From: TownPlanning LNW [TownPlanningLNW@networkrail.co.uk]
Sent: 16 December 2013 09:48
To: planning
Subject: Ribble Valley ref 3-2013-0981 Chatburn Rd Clitheroe 20 dwellings- 3 apartments-60 bed care home

3/2013/0981

LAND AT CHATBURN ROAD, CLITHEROE

20 DWELLINGS, 3 CLOSE CARE APARTMENTS, 60 BED CARE HOME

Fig 1: Site Plan

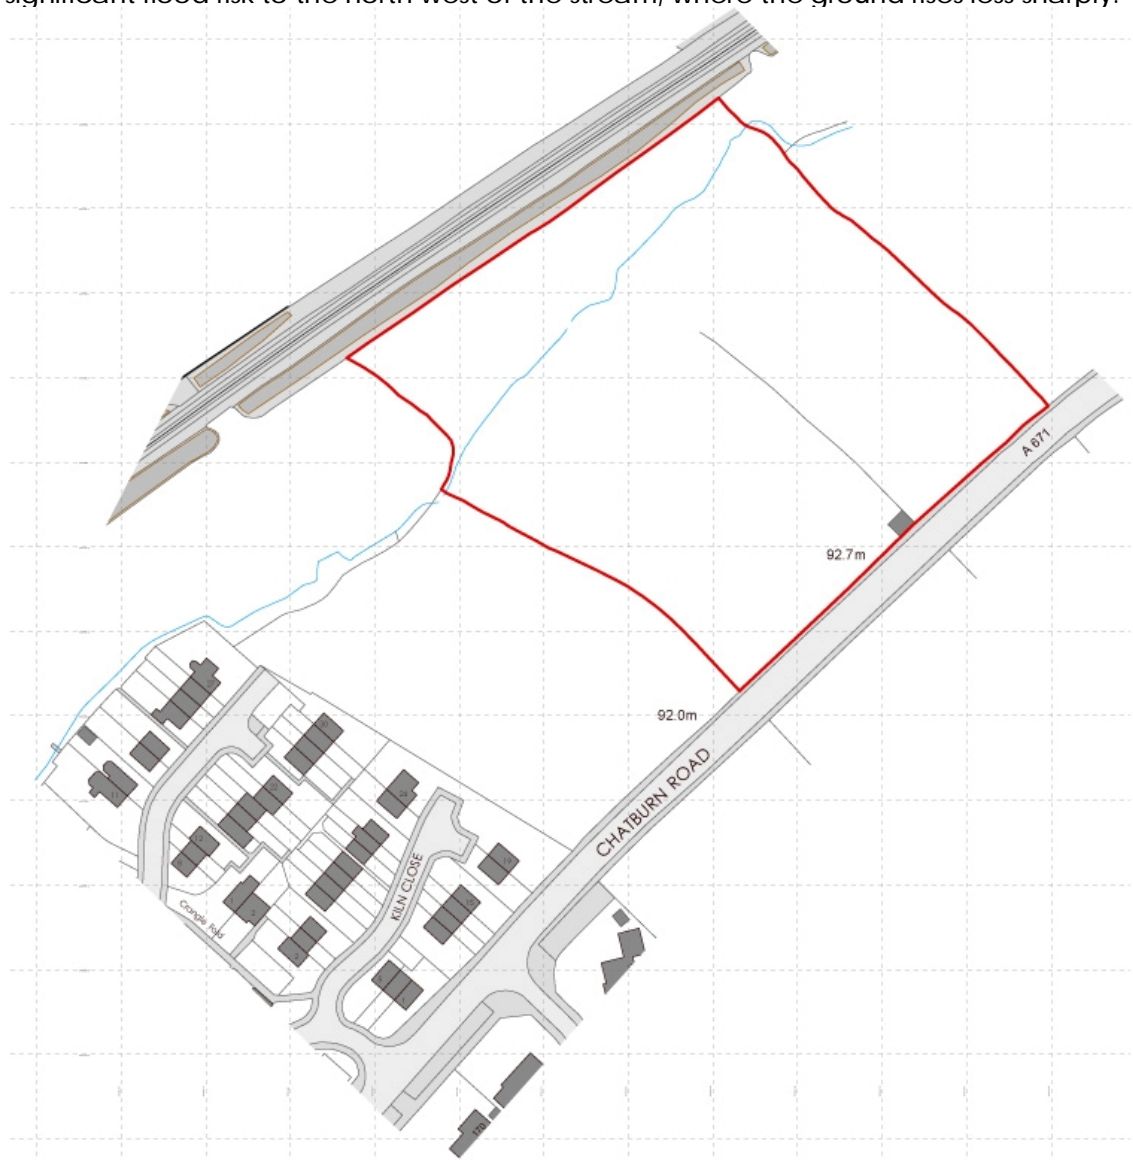
The site plan shows that there will be screening adjacent to the railway line. Network Rail would request that no trees are planted next to the boundary with our land and the operational railway. Network Rail would request that only evergreen shrubs are planted and we would request that they should be planted a minimum distance from the Network Rail boundary that is equal to their expected mature growth height.
